CITY OF PORTLAND

Permit Number: 061066

AT 71 BALLPARK DR _____ 371 A040001

Proposed Project Description: Single family w/ attached garage	FIRE DEPT: <input type="checkbox"/> Approved <input type="checkbox"/> Denied <i>N/A</i>	INSPECTION: Use Group: <i>R-3</i> Type: <i>SB</i> <i>IBC 2003</i>
	Signature:	Signature:

BASEMENT FOUNDATION
Scale: 1/4" = 1'-0"
2129

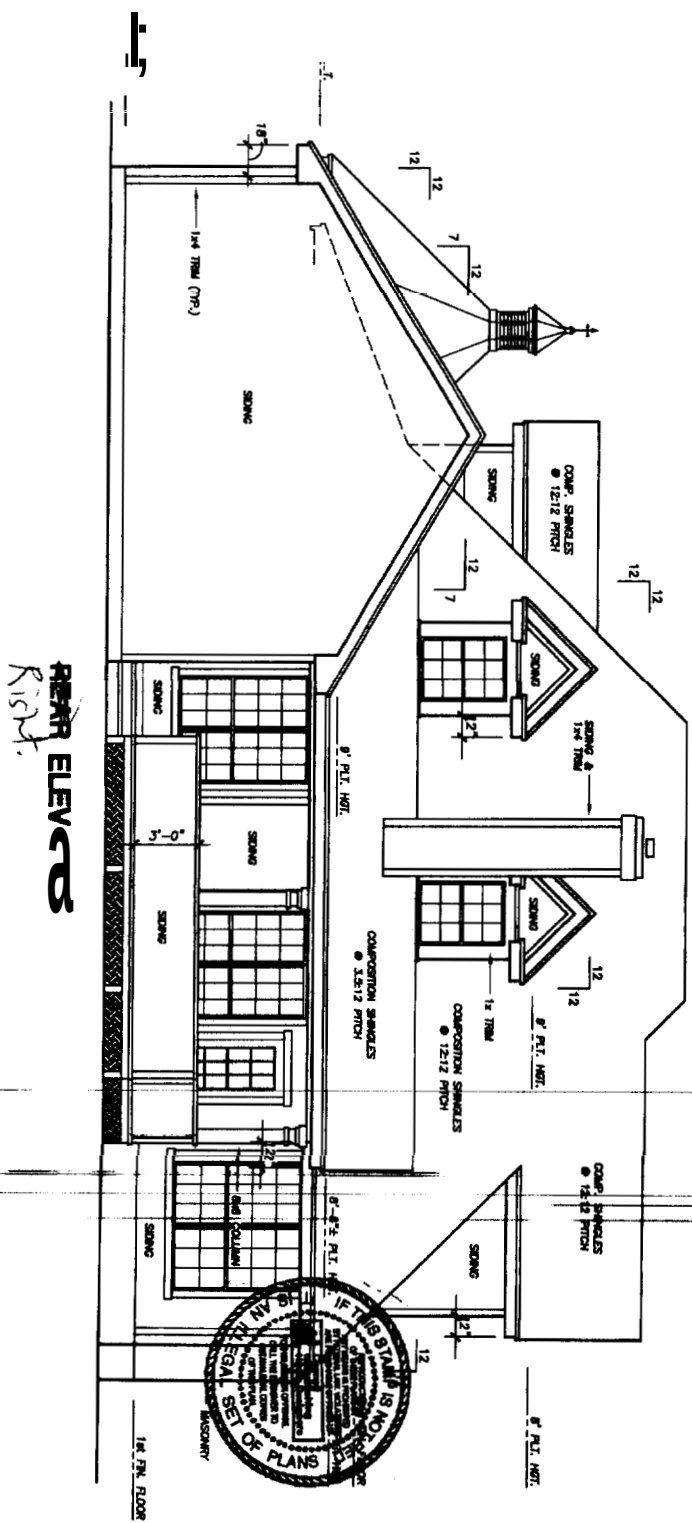
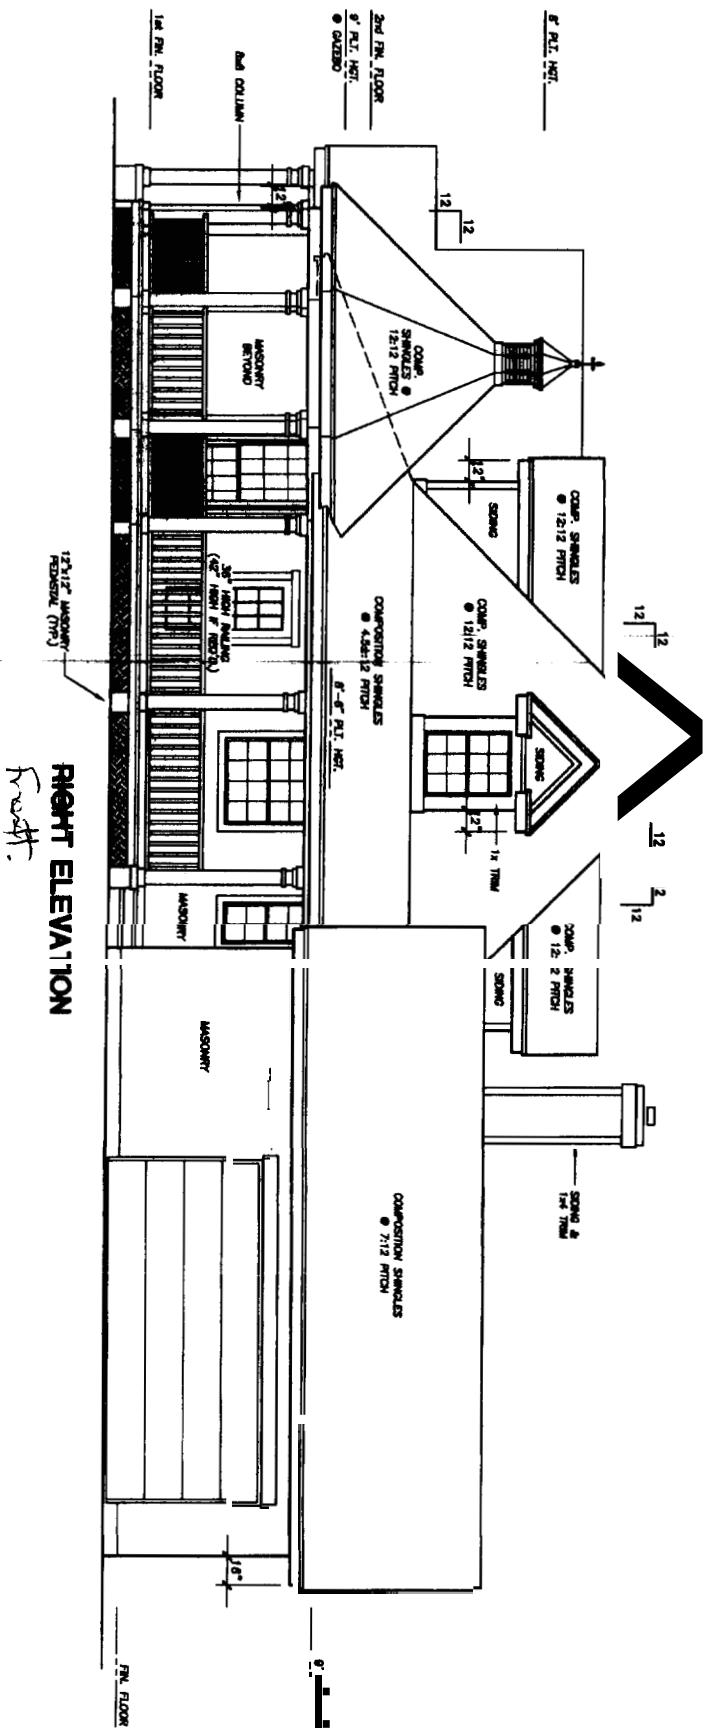
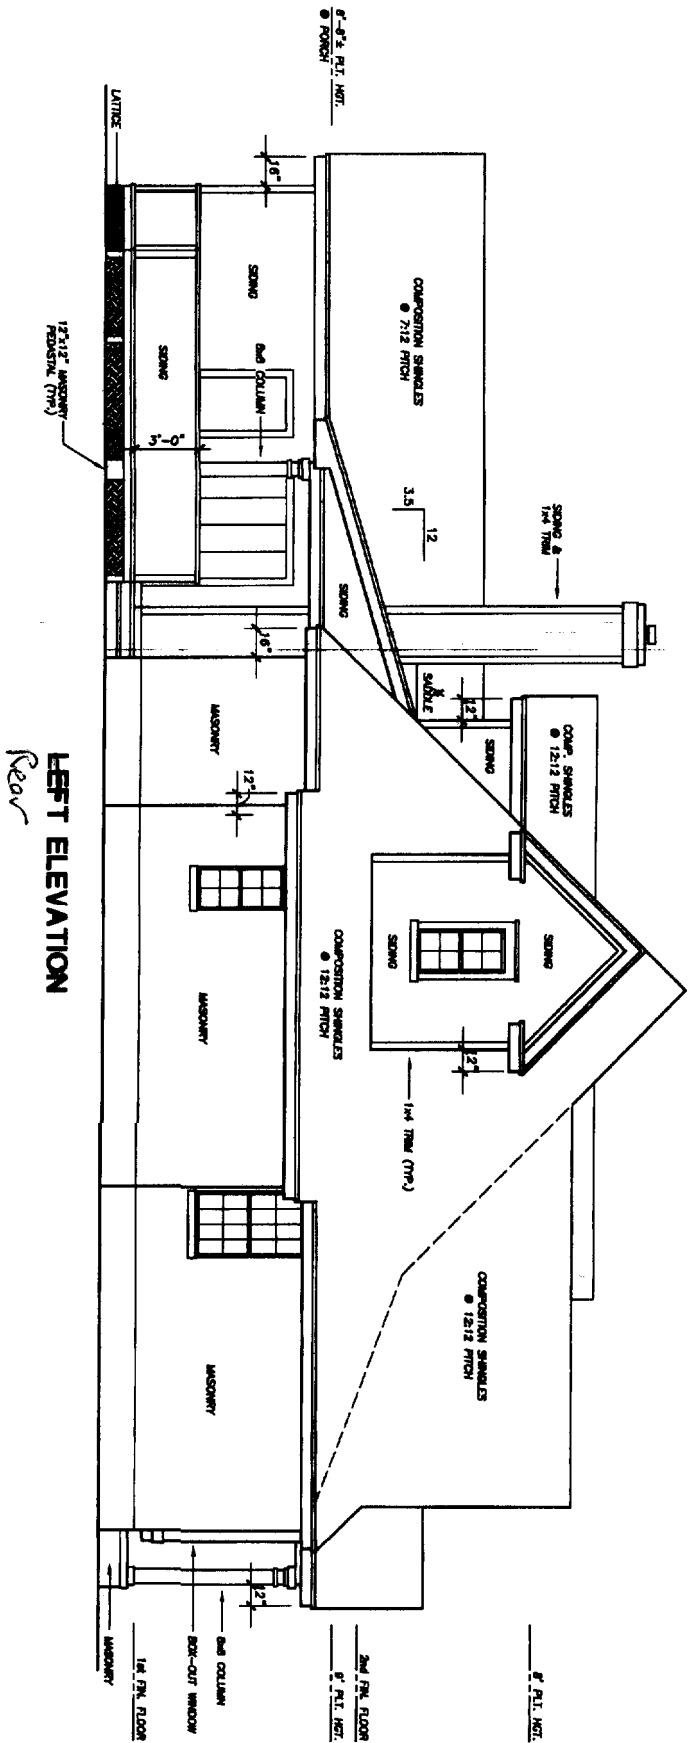
ONE AND TWO FAMILY Soil type/Presumptive Load Value (Table R401.4.1)	PLAN REVIEW	CHECKLIST
STRUCTURAL		
Footing Dimensions/Depth (Table R403.1 & R403.1(1)), (Section R403.1 & R403.1.4.1)	No foundation details or plan	OK
Foundation Drainage, Fabric, Damp proofing (Section R405 & R406)	No foundation	OK
Ventilation/Access (Section R408.1 & R408.3) Crawls Space ONLY	No foundation	OK
Anchor Bolts/Straps, spacing (Section R403.1.6)	No foundation	OK
Fully Column Type (Section R407)	Need beam specs	if
Girder & Header Spans (Table R 502.5(2)) Built-Up Wood Center Girder	LVL's are used	or Girders girder under sized
Dimension/Type Sill/Band Joist Type & Dimensions	NOT SHOWN	ADD COMMENTS
First Floor Joist Species Dimensions and Spacing (Table R502.3.1(1) & Table R502.3.1(2))	2x12's - 11'6" Max span - OK	ADD COMMENTS
Second Floor Joist Species Dimensions and Spacing (Table R502.3.1(1) & Table R502.3.1(2))	2x12's - 12" oc - OK of 17'-5" for 30 psf (slipping)	max. allowed span INCL. FLOOR JOIST
